Final Report - Corrections Required **Application No. SUBD-26-0036**

Report Date: 07/23/2026

Description : 39 single family lot community directly north of filing 10.

Document Filename : FP_V2_7-9-26.pdf

REVEL AT WOLF RANCH
FILING NO. 11
JOB NO. 2555.48
JUNE 15, 2026
SHEET 2 OF 2

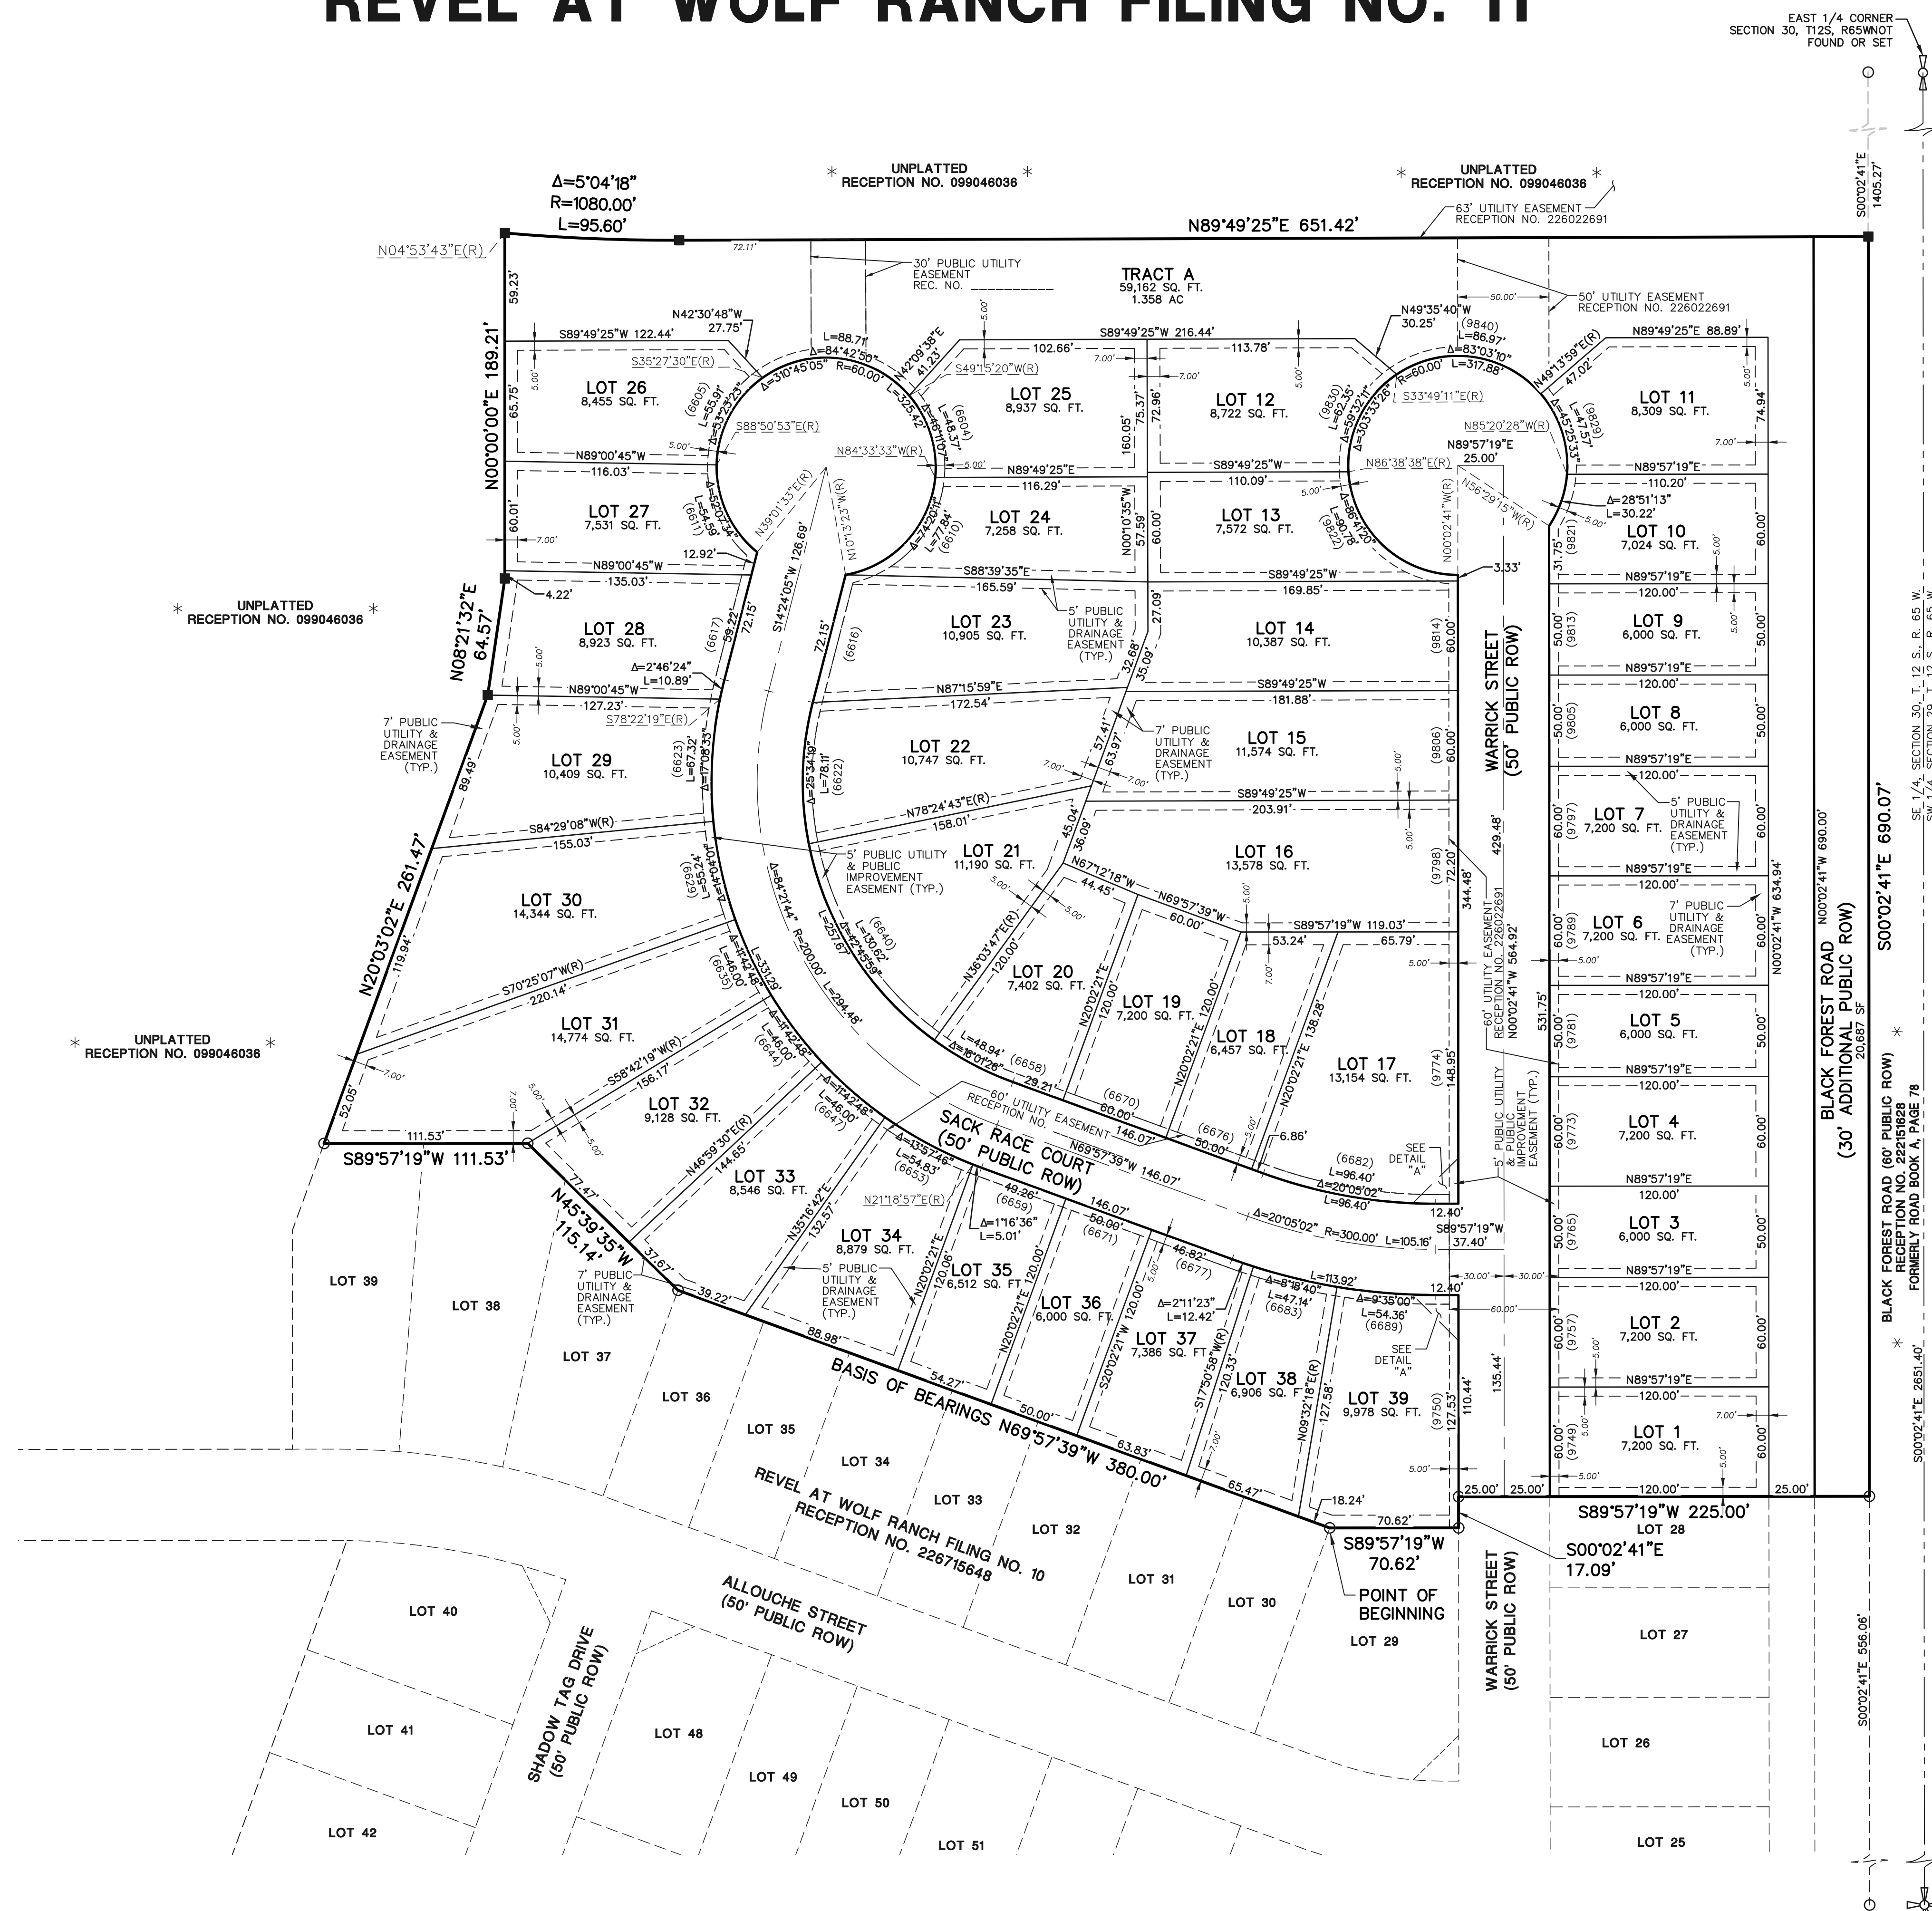
Comment ID	Page Reference	Reviewer : Department	Review Comments
25	2	Matthew Alcuran : Col Springs Utilities	Show and label existing utility infrastructure per City Final Plat Checklist. This can be shown on a separate Utility Exhibit that is not part of the recordation process. Staff need to confirm the location of any water, wastewater, gas, or electric mains or Services that are crossing new lot lines.
29	2	Barbara Reinardy : Real Estate Services	SUBD-26 (vs. 24)
